Application no: 23/02713/DISC

Location: OS Parcel 6372 South East Of Milestone Farm, Broughton Road, Banbury

Transport Development Control

DRAWING TITLE: **HIGHWAY TIE-IN PLAN**

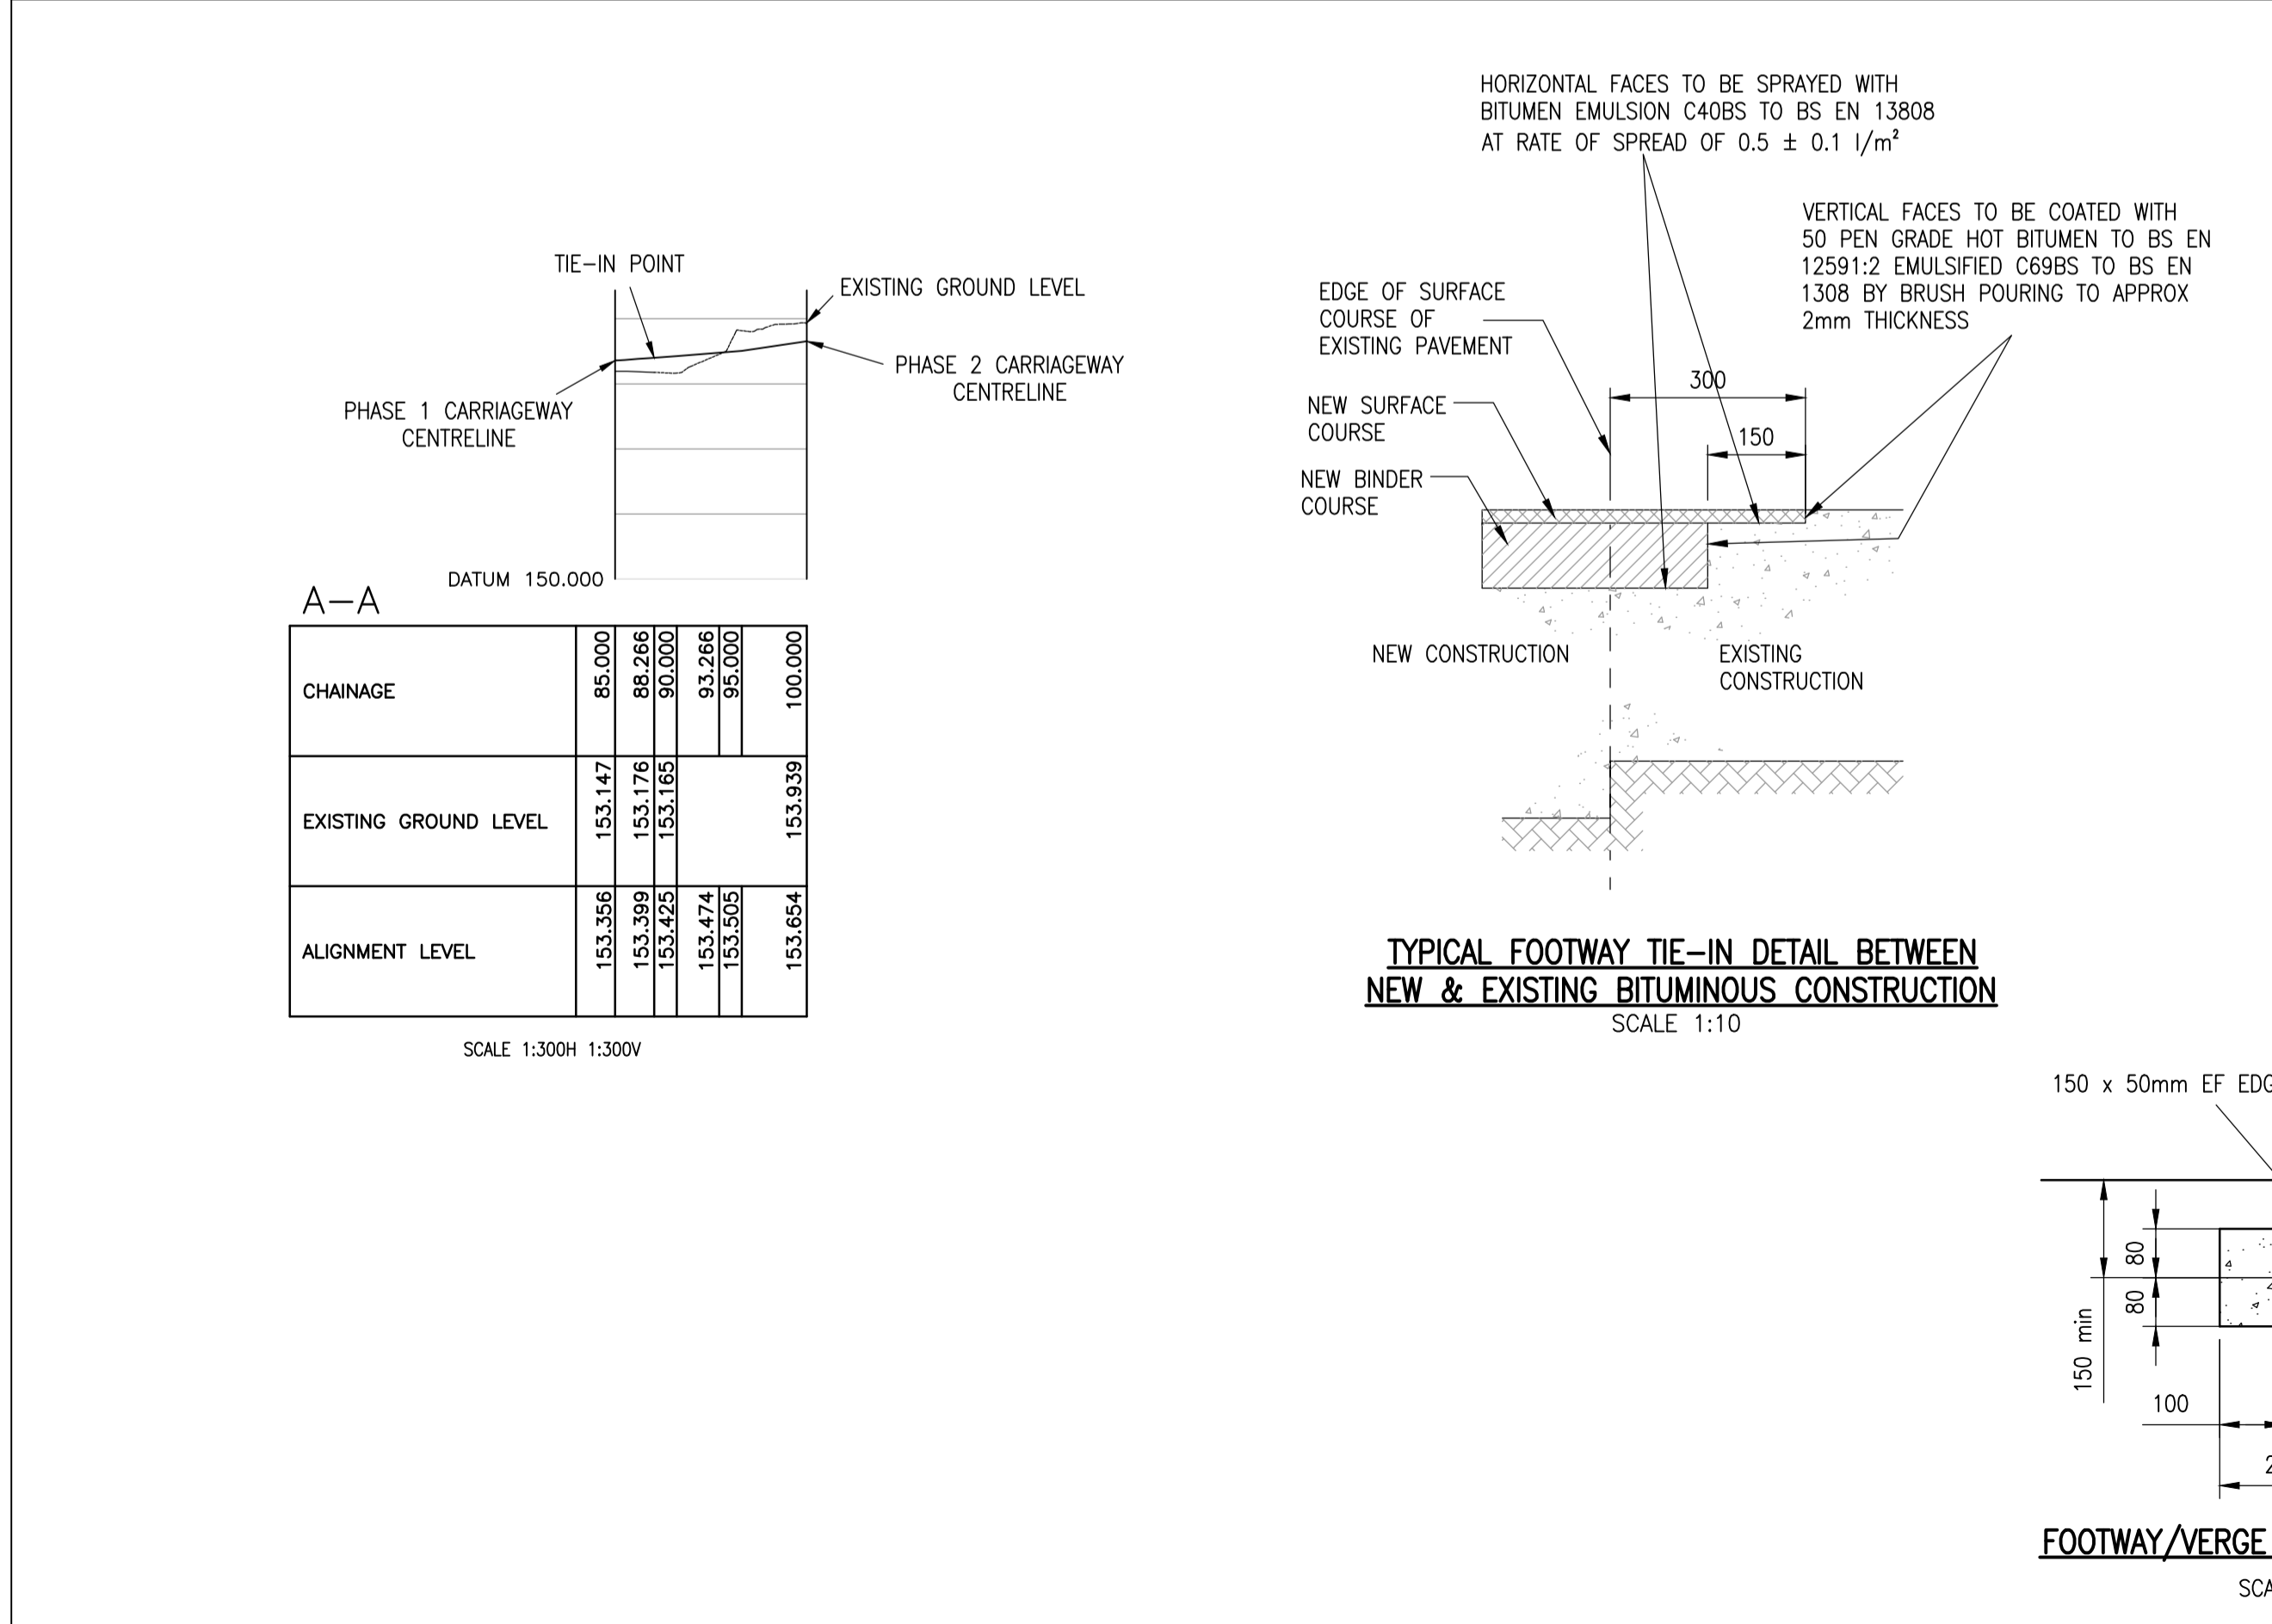
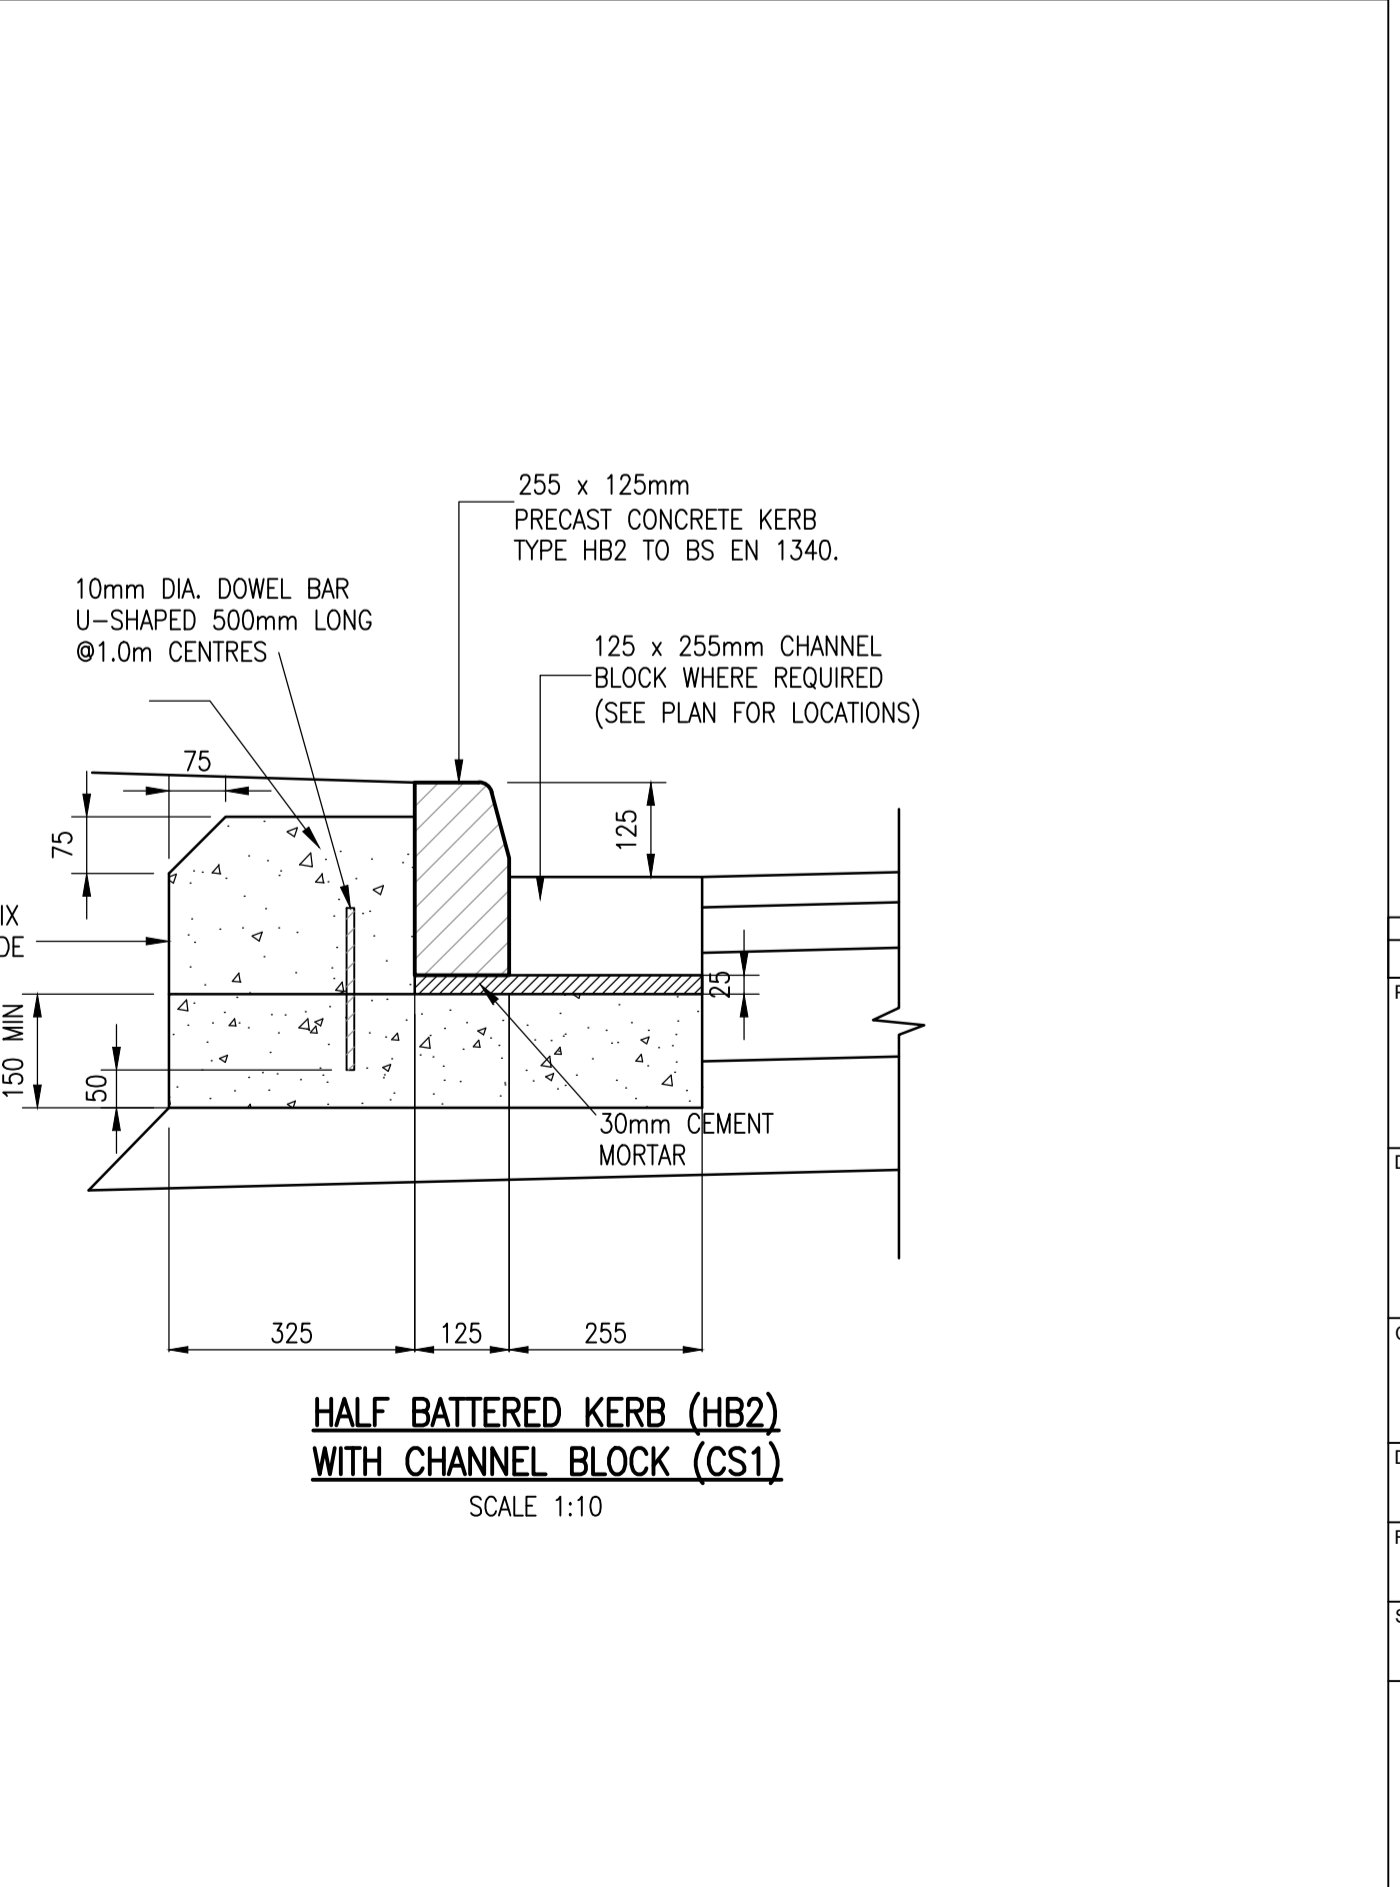
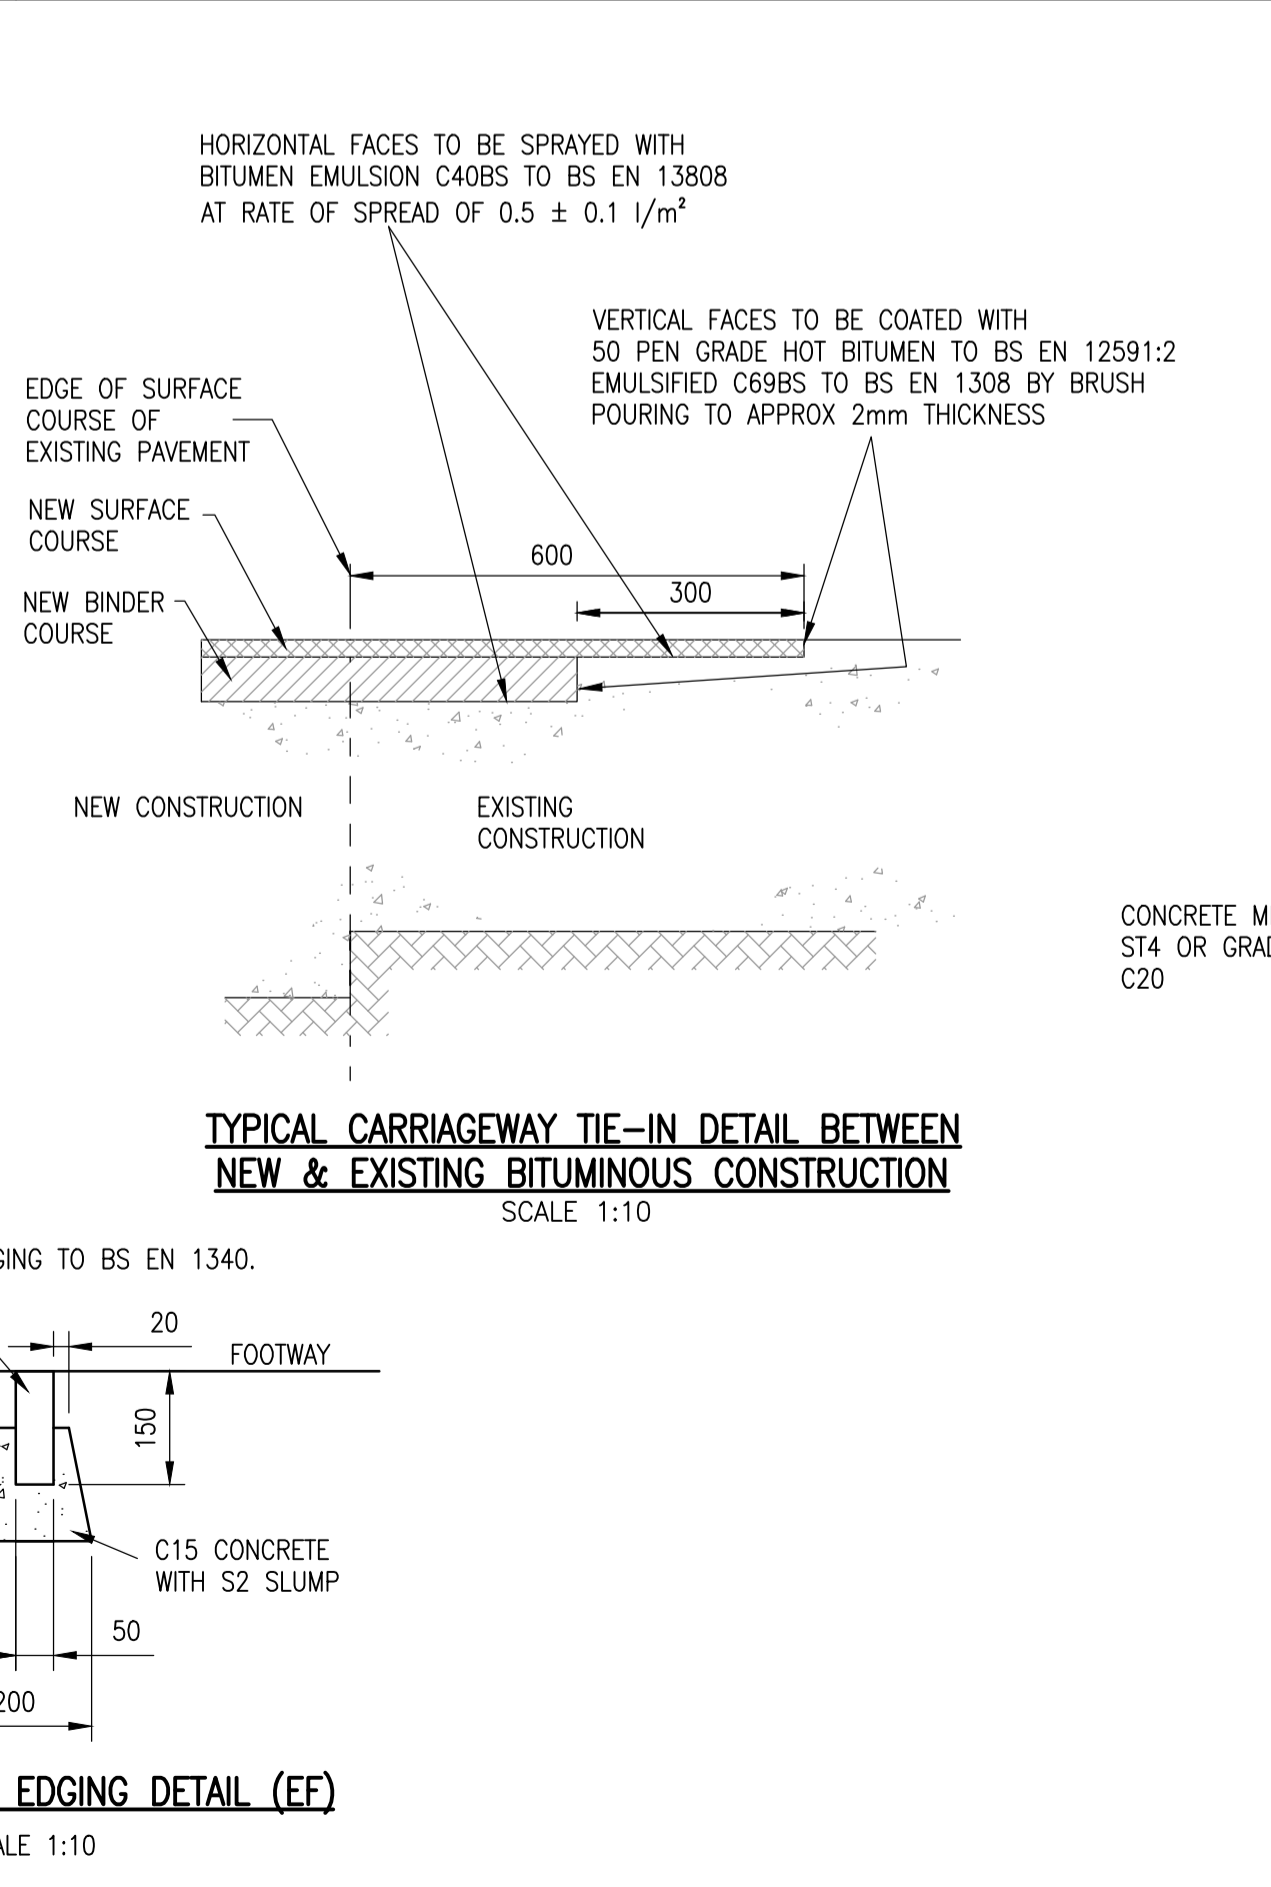
Condition 11: No objection in principle

Please note that amendments may be required at technical approval stage.
